## *Landscape Briefing Note 7*

*Project:* 1080 East Anglia One North and East Anglia Two  
*Date:* 24<sup>th</sup> March 2021  
*Purpose:* Notes responding to SPR's Deadline 6 submission  
*Reference:* 1080 BN07 Responses to Deadline 6 submissions.docx

Outline Operational Drainage Management Plan - Version 03 24/02/21 **REP6-017**

DRG No.	ED11892-C-SK10	REV	G
DRG SIZE	A3	SCALE	NTS
DATE	SEPT'20	APPROVED BY	SH
DRAWN BY	JN	CHECKED BY	CS

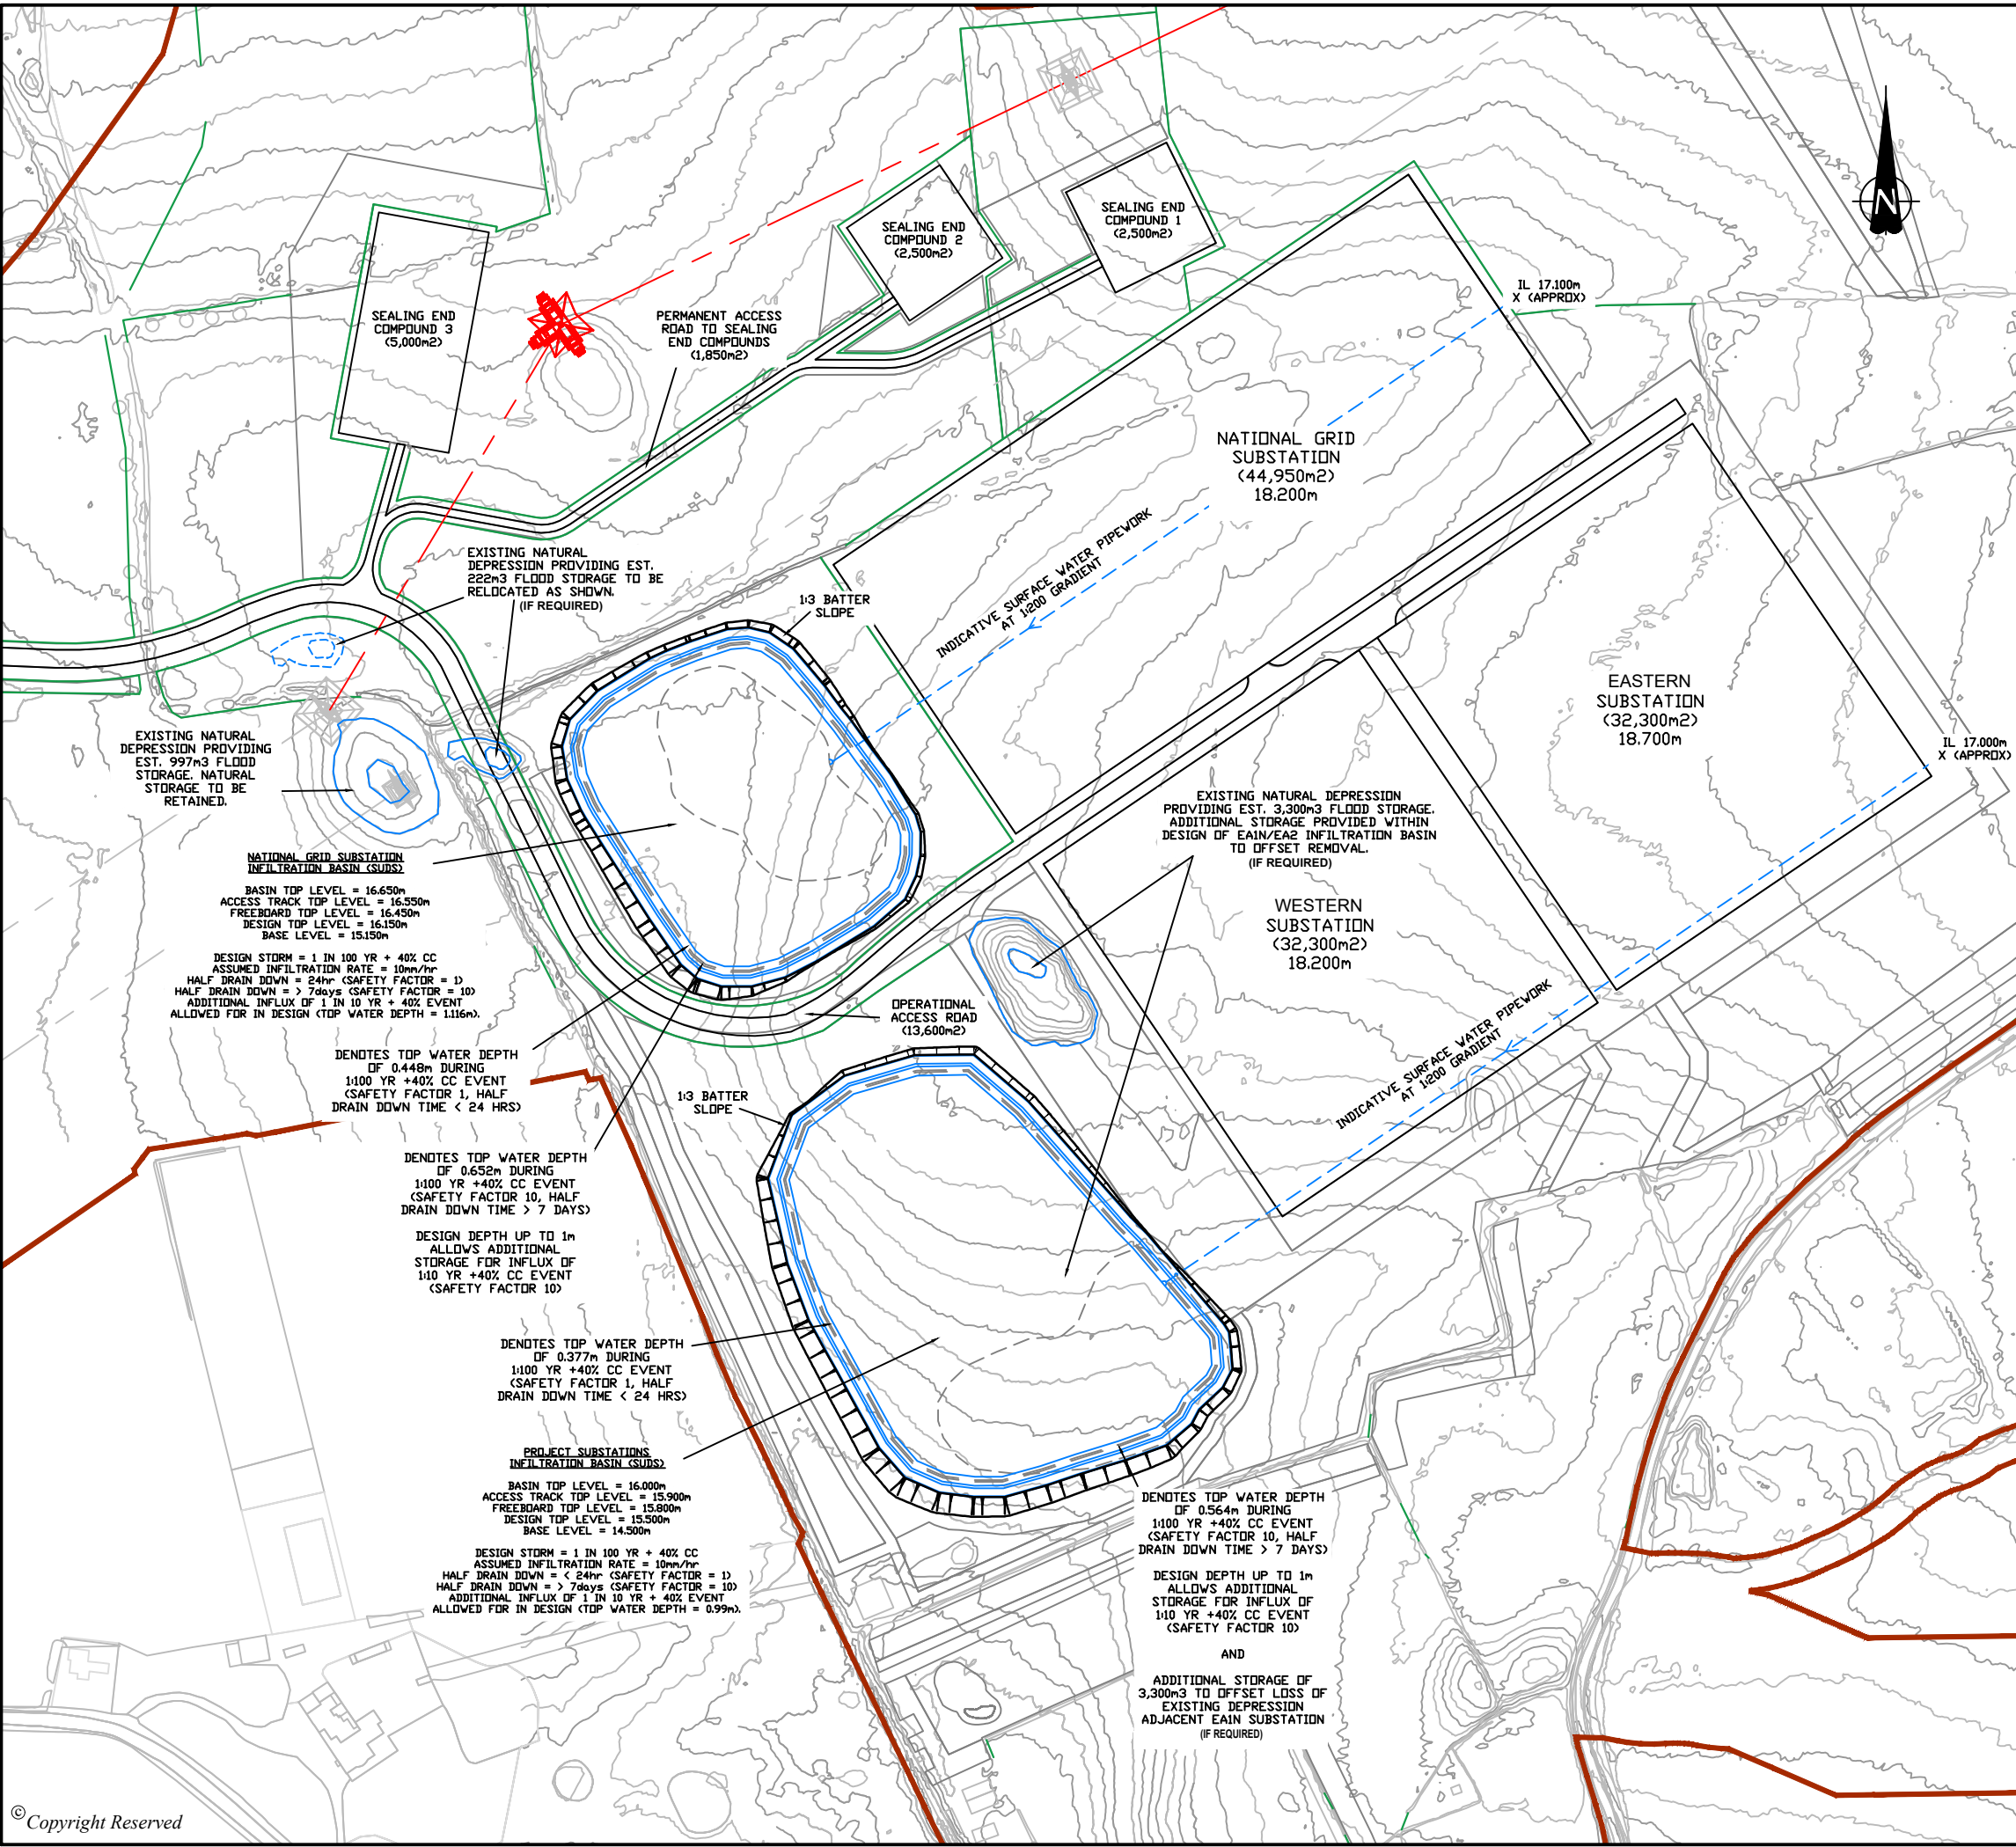
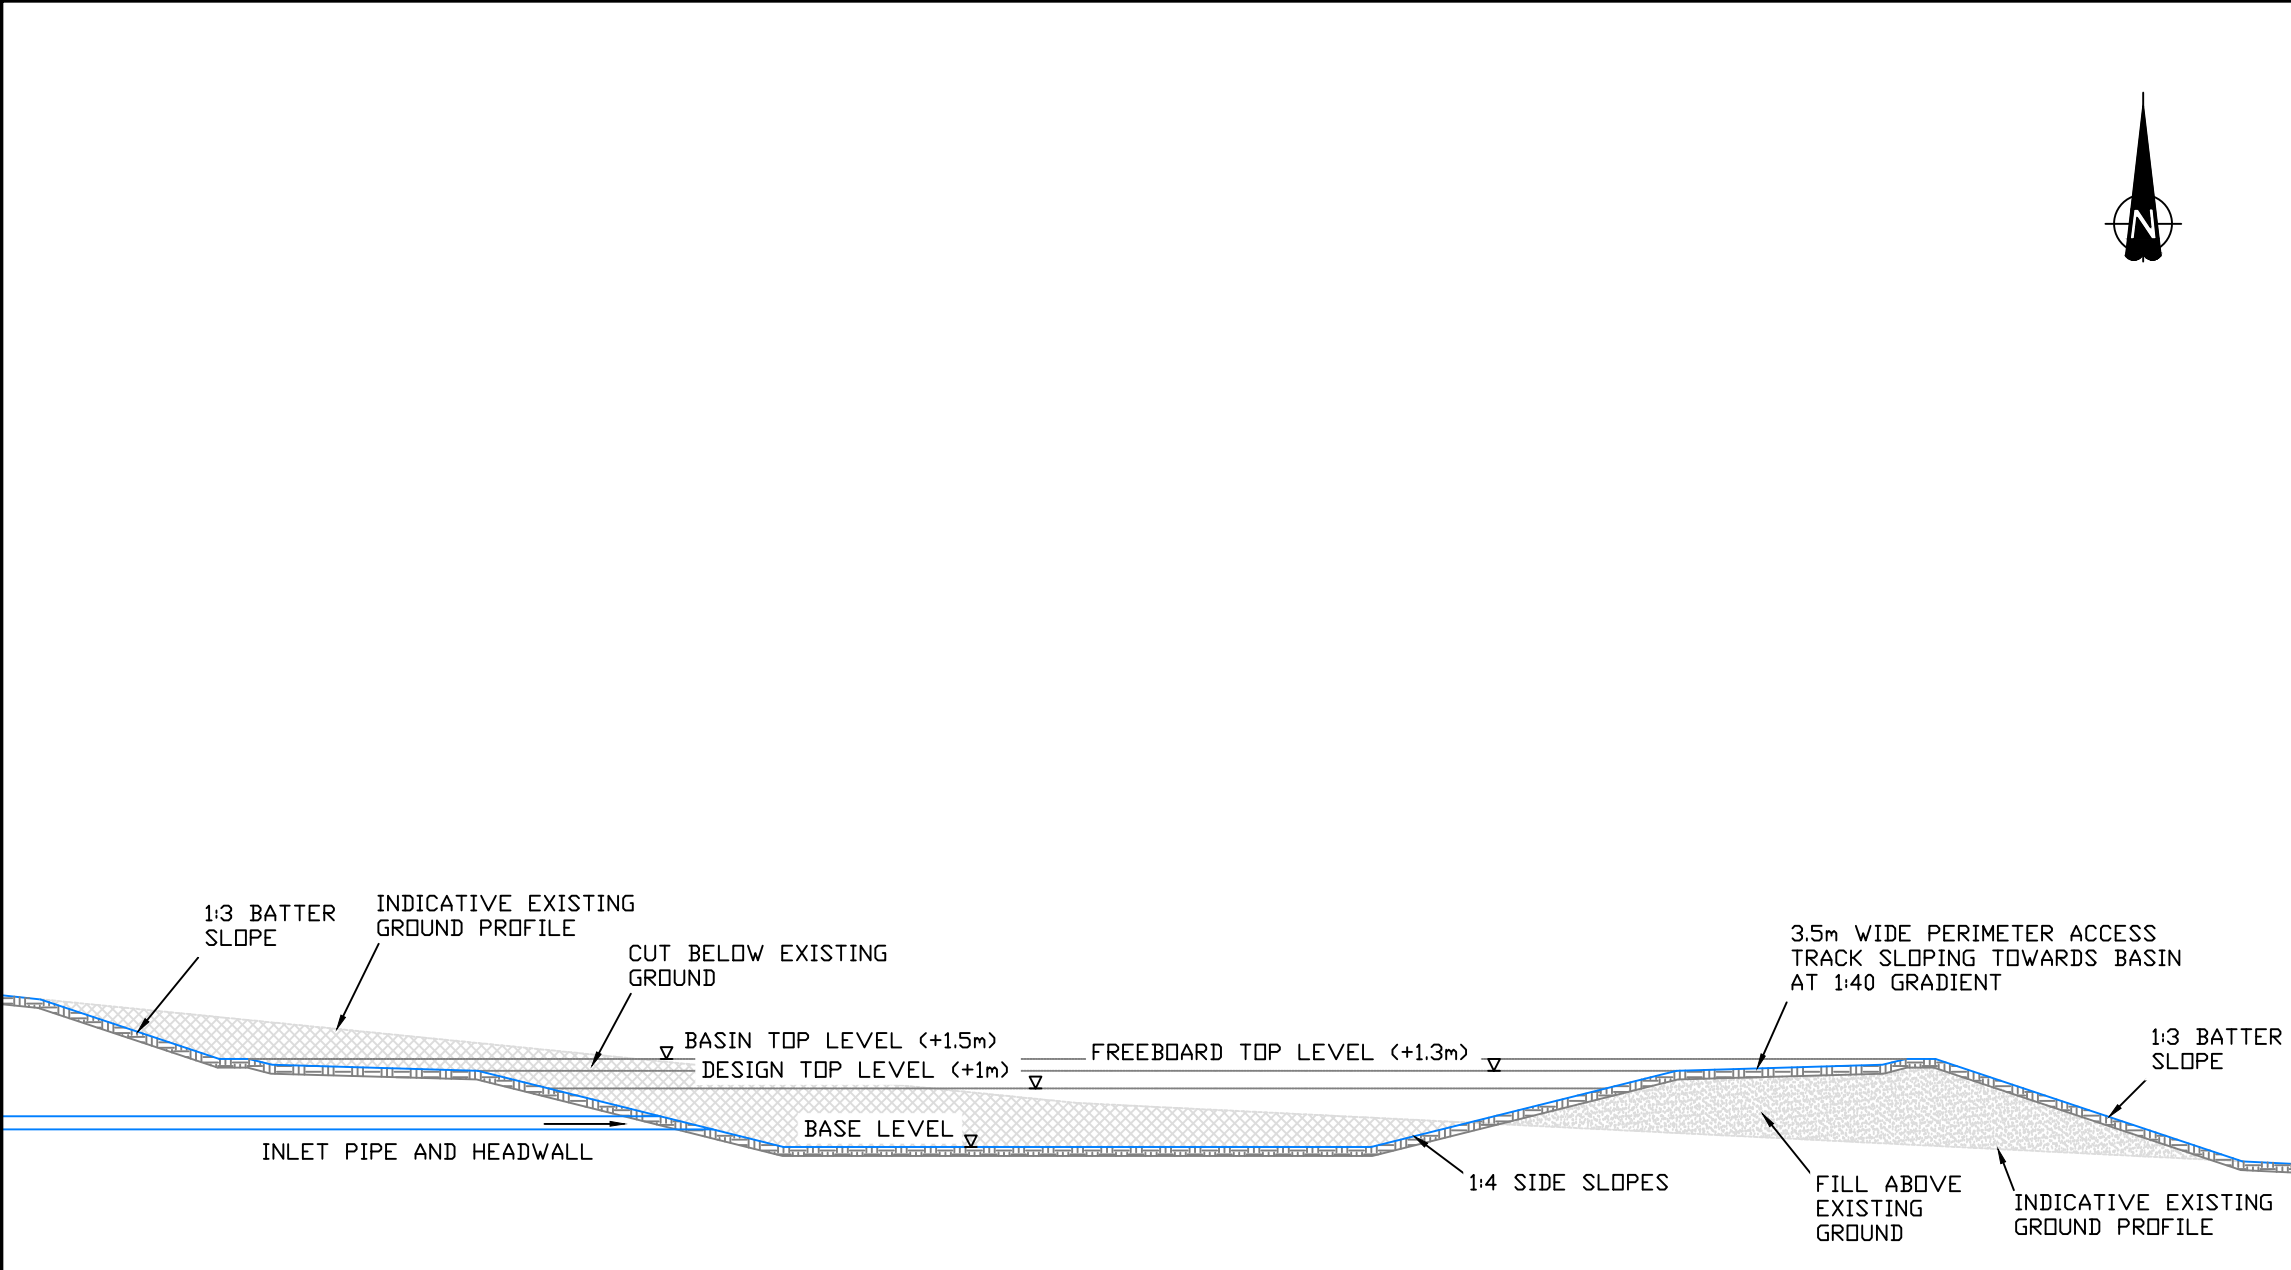
1. The latest Outline Operational Drainage Management Plan (Outline Operational Drainage Management Plan - Version 03 24/02/21 **REP6-017**) includes a sketch figure showing an Option for infiltration basins (Wardell Armstrong Dwg ED11892-C-SK10 Infiltration Basin 10mm Per Hour Options Sketch)

3. From Figure 16 it can be seen that the infiltration basins are considerably larger than the basins shown on the OLMP Proposed Planting Plan and would have the following consequences for the planting:

- The triangular area of mitigation woodland located to the south west of the northern basin would have to be omitted.
  - Whilst a small strip of planting could be accommodated to the west of the northern basin it would need to allow access to the embankments for maintenance purposes and would be constrained by the access road.

- Access to the embankments for maintenance purposes would reduce the area for woodland planting along the southern and western edges of the southern basin.

- 
4. The OLMP Proposed Planting Plan shows areas of tree planting within the infiltration basins. It is unclear why these have been introduced as they will require an overall enlargement of the area of infiltration basins. It is questionable whether trees in these locations and close to the edge of the basins would be compatible with the engineered structures of the Infiltration basins.

5. The OLMP V03 (**REP6-007**) was issued on the same date as the Outline Operational Drainage Management Plan - Version 03 (**REP6-017**) but does not reflect the proposed enlargement of the basins. This suggests that the landscape implications of enlarging the basins have not yet been considered.

6. The removal of the woodland from the southern and western edges of the northern infiltration basin will limit the effectiveness of the proposed mitigation in views from Footpath 17 which is located to the west of the proposed infiltration basins. The only LVIA Vp from Fp 17 is Vp 1. The grassed bund visible in the visualisation from Vp 1 (EA1N Landscape and Visual Impact Assessment Addendum - Appendix 1 - Viewpoint 1 **REP4-032**) is the edge of the drainage basin. The visualisation shows no planting on the embankments and, as set out above, a maintenance access strip would need to be kept clear along the foot of the embankment, further limiting the planting.

9. The embankments of both infiltration basins will now be close to and parallel with Fp 17 for approximately 350m. Previously only 80m of the southern basin was close to and parallel with Fp 17.

12. The new proposals for infiltration basins as set out on Dwg ED11892-C-SK10 (Outline Operational Drainage Management Plan - Version 03 24/02/21 REP6-017) will exacerbate the already significant harm to the visual amenity of the one remaining northbound PRoW to the north of Friston. They would further reduce the amenity of the landscape to the north of Friston as a resource for residents and visitors.
